**WELWYN HATFIELD COUNCIL – DEVELOPMENT CONTROL**  
**DELEGATED REPORT**

<b>APPLICATION No:</b>	<b>S6/2008/787/FP</b>
------------------------	-----------------------

The application seeks full planning permission for roof alterations to incorporate first floor accommodation consisting of roof enlargement and part raising of ridge line and new front dormer window.

Front Elevation with adjacent properties

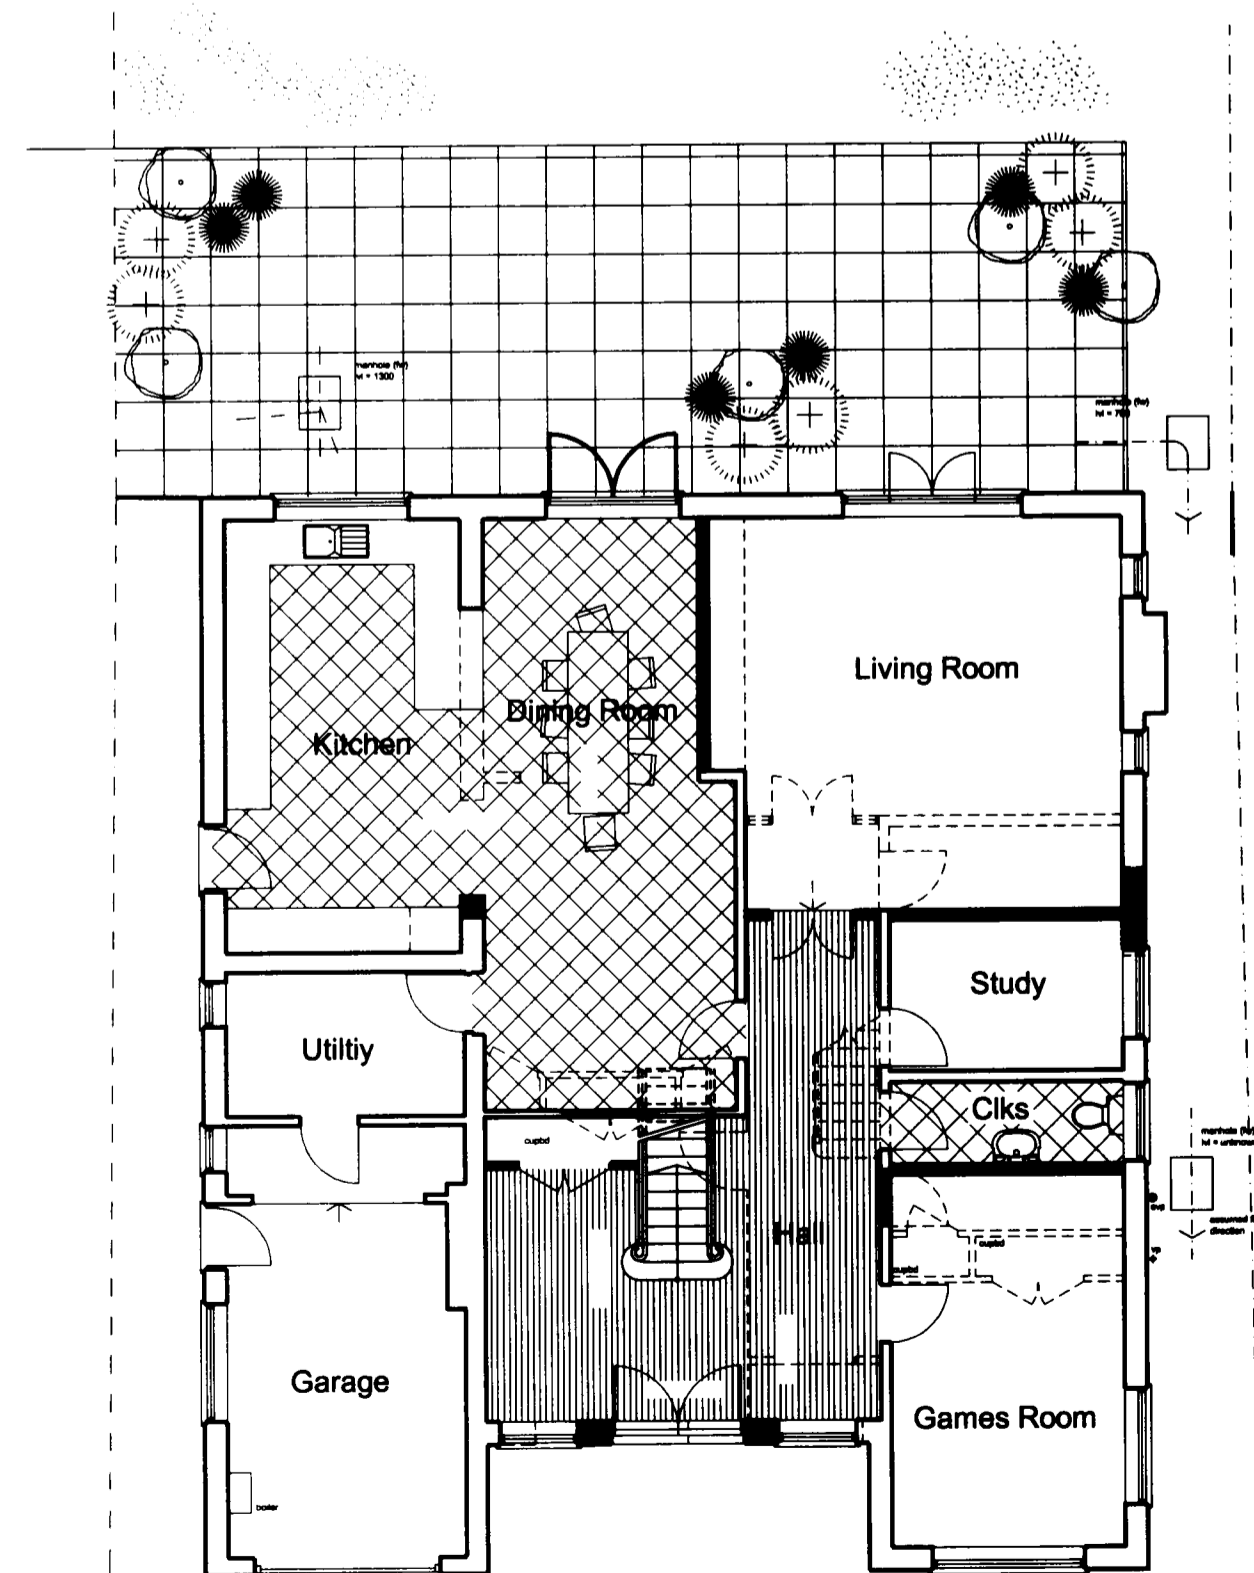
The previous scheme had a marginally higher ridge line (approximately 0.2 metres higher) in comparison to this scheme; however the style was different in that there was reduced bulk, massing and prominence. Additionally, it is considered that the roof alterations would be highly visible from the street scene and would close up an important visual gap between adjacent properties.

In conclusion, it is considered that despite the dwellings within the immediate street scene, the proposed roof alterations are considered to create a more prominent dwelling due to the scale, bulk, massing and design and the insertion of further dormer windows would create additional bulk to the roofslope. This fails to comply with Section (ii) of Policy RA3 (Extensions to Dwellings in the Green Belt) and the advice contained within PPG2.

1) The proposal by virtue of its bulk, scale, massing and design would encroach into an important visual gap and result in a prominent structure, which would have a detrimental impact on the character, appearance and openness of this part of the Green Belt, Landscape Conservation Area and the visual interest of its surroundings. The proposal is therefore contrary to the advice contained within PPG2 and Policies RA3 and RA10 of the Welwyn Hatfield District Plan 2005.

Roof Plan

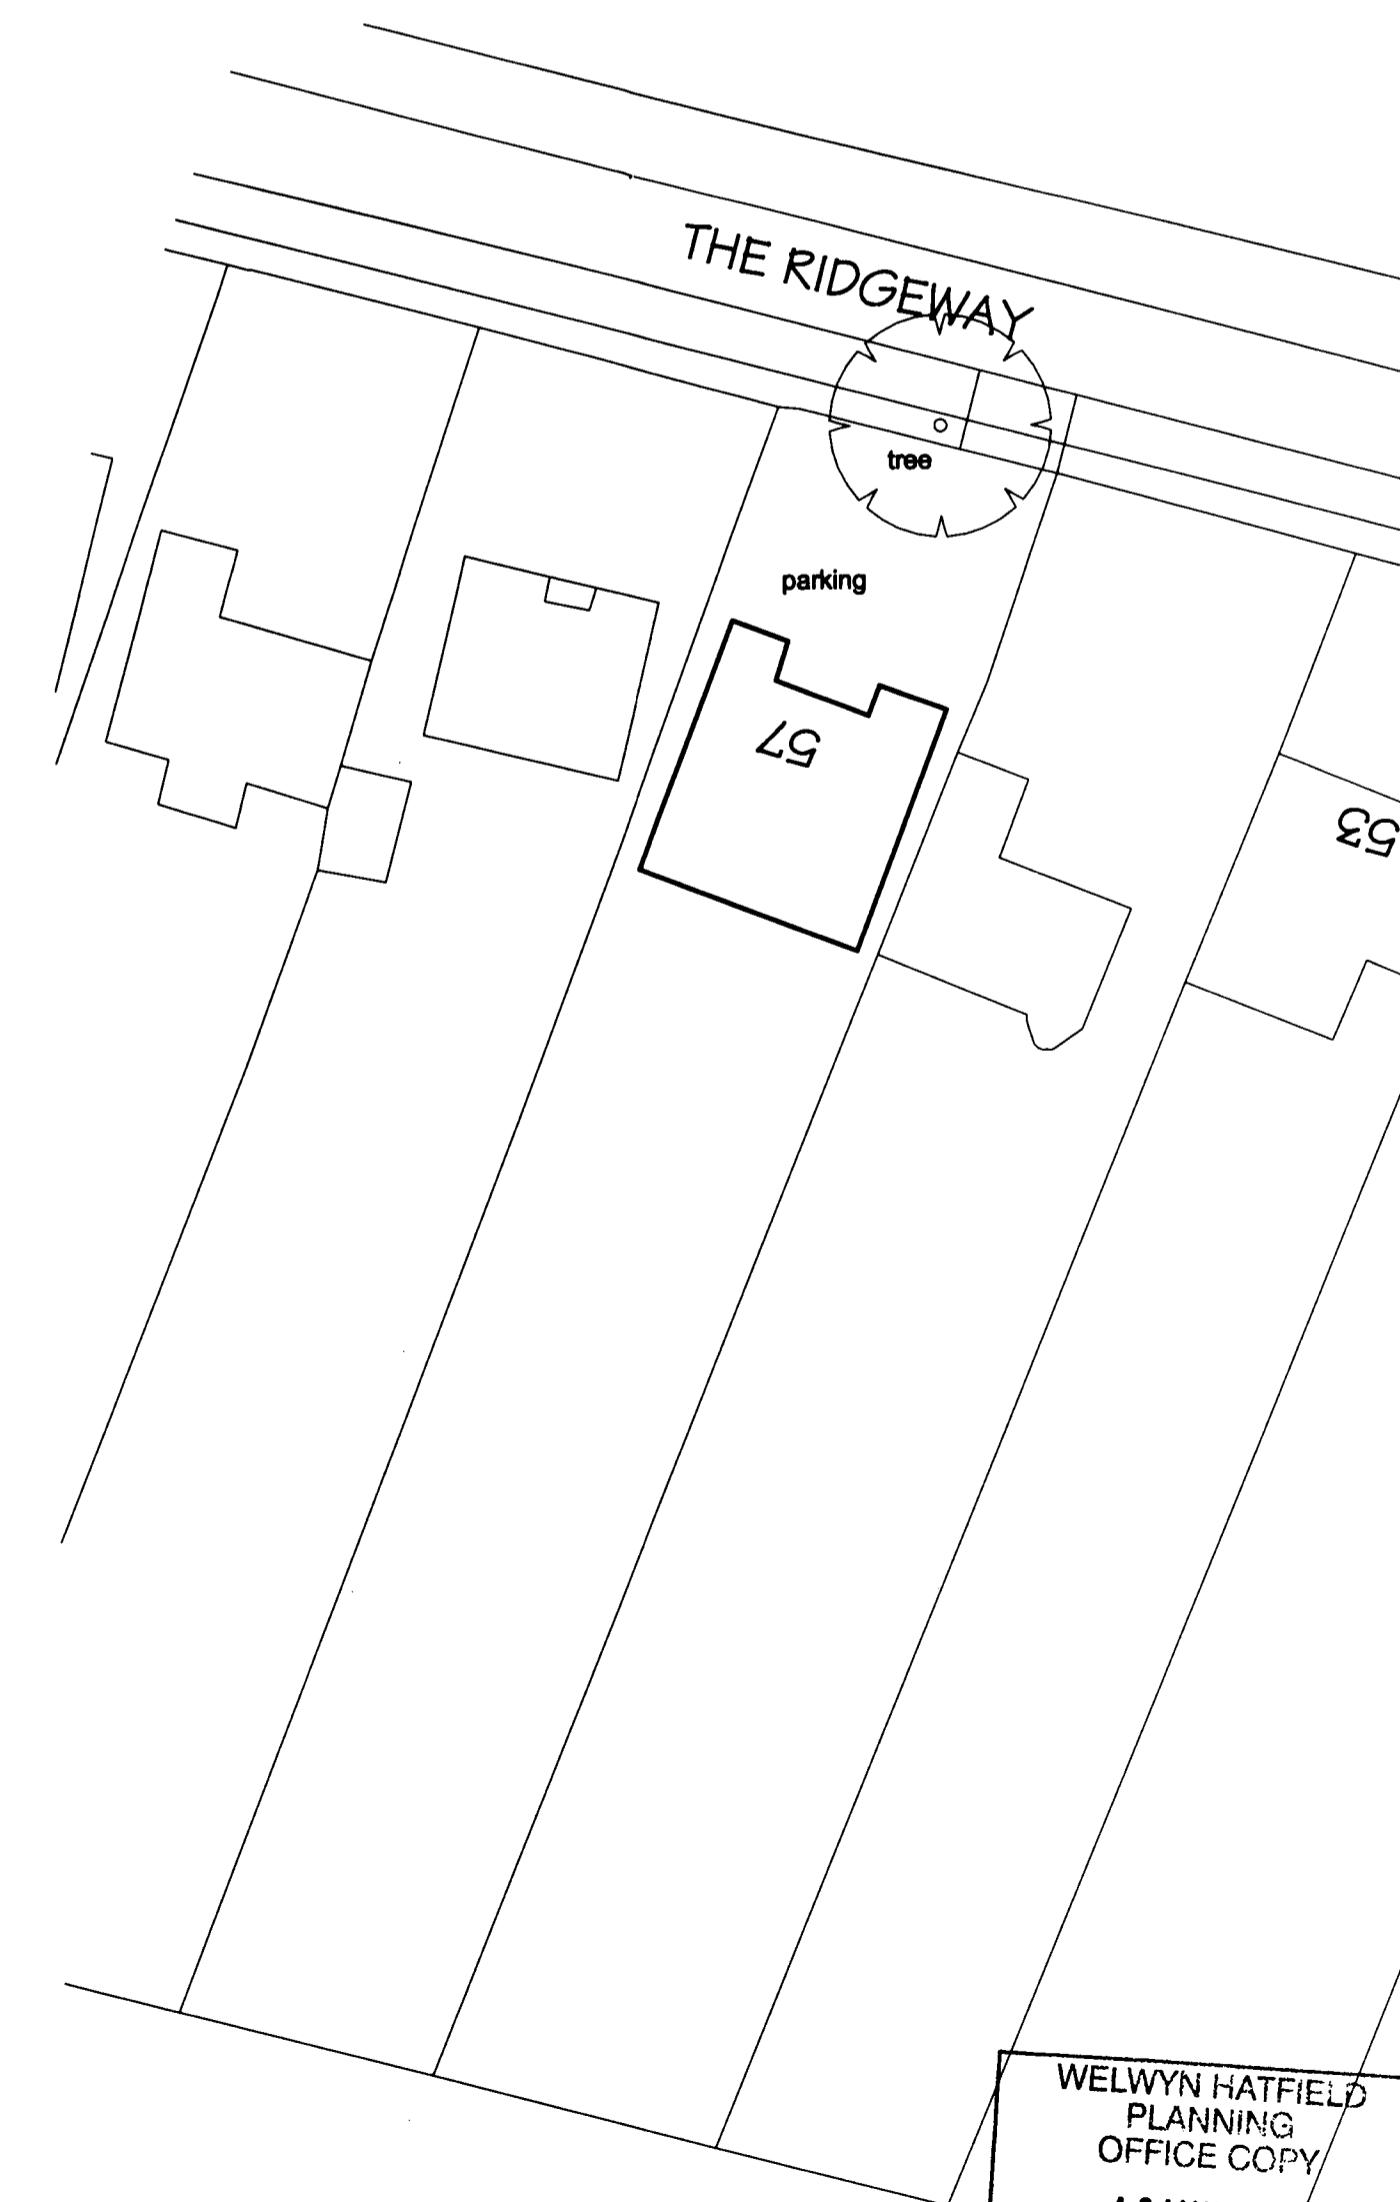
The highest point of the existing dwelling is an apex point, which projects approximately 1.5 metres above the rest of the roofline. The proposed scheme seeks to reconfigure the roof to maintain the ridgeline at approximately 6.8 metres. It is also proposed to remove the existing flat roof dormer window within the front roofspace and replace it with two hipped roof dormer windows. The existing dormer window and rooflight within the rear roofslope would also be removed and replaced with two windows. It is also proposed to insert two additional rooflights within the side (east) elevation and another in the side (west) elevation to serve the ensembles bathrooms. A roof lantern would also be inserted within the roofslope to provide for the hallway and landing.

The proposal would still use the resultant roofspace for the new first floor accommodation, albeit in reconfigured style. When comparing this scheme to the original bungalow granted under planning permission E/746/54 and the more recently approved scheme S6/2007/1207/FP, it appears that the dwelling has altered from its original built form of a low density bungalow. The current scheme proposes to further alter the appearance of the property to resemble that of a more chalet styled bungalow. The main visual impact would result from the roof enlargement, which incorporates gabled ends with hipped tops to the side elevations and an overall bulkier structure when viewed from the street scene and other public vantage points. Additionally, the ridgeline would be part raised and maintained at a height of approximately 6.8 metres, which involves the loss of the existing apex point of 7.6 metres; however a large proportion would be raised by 0.7 metres.
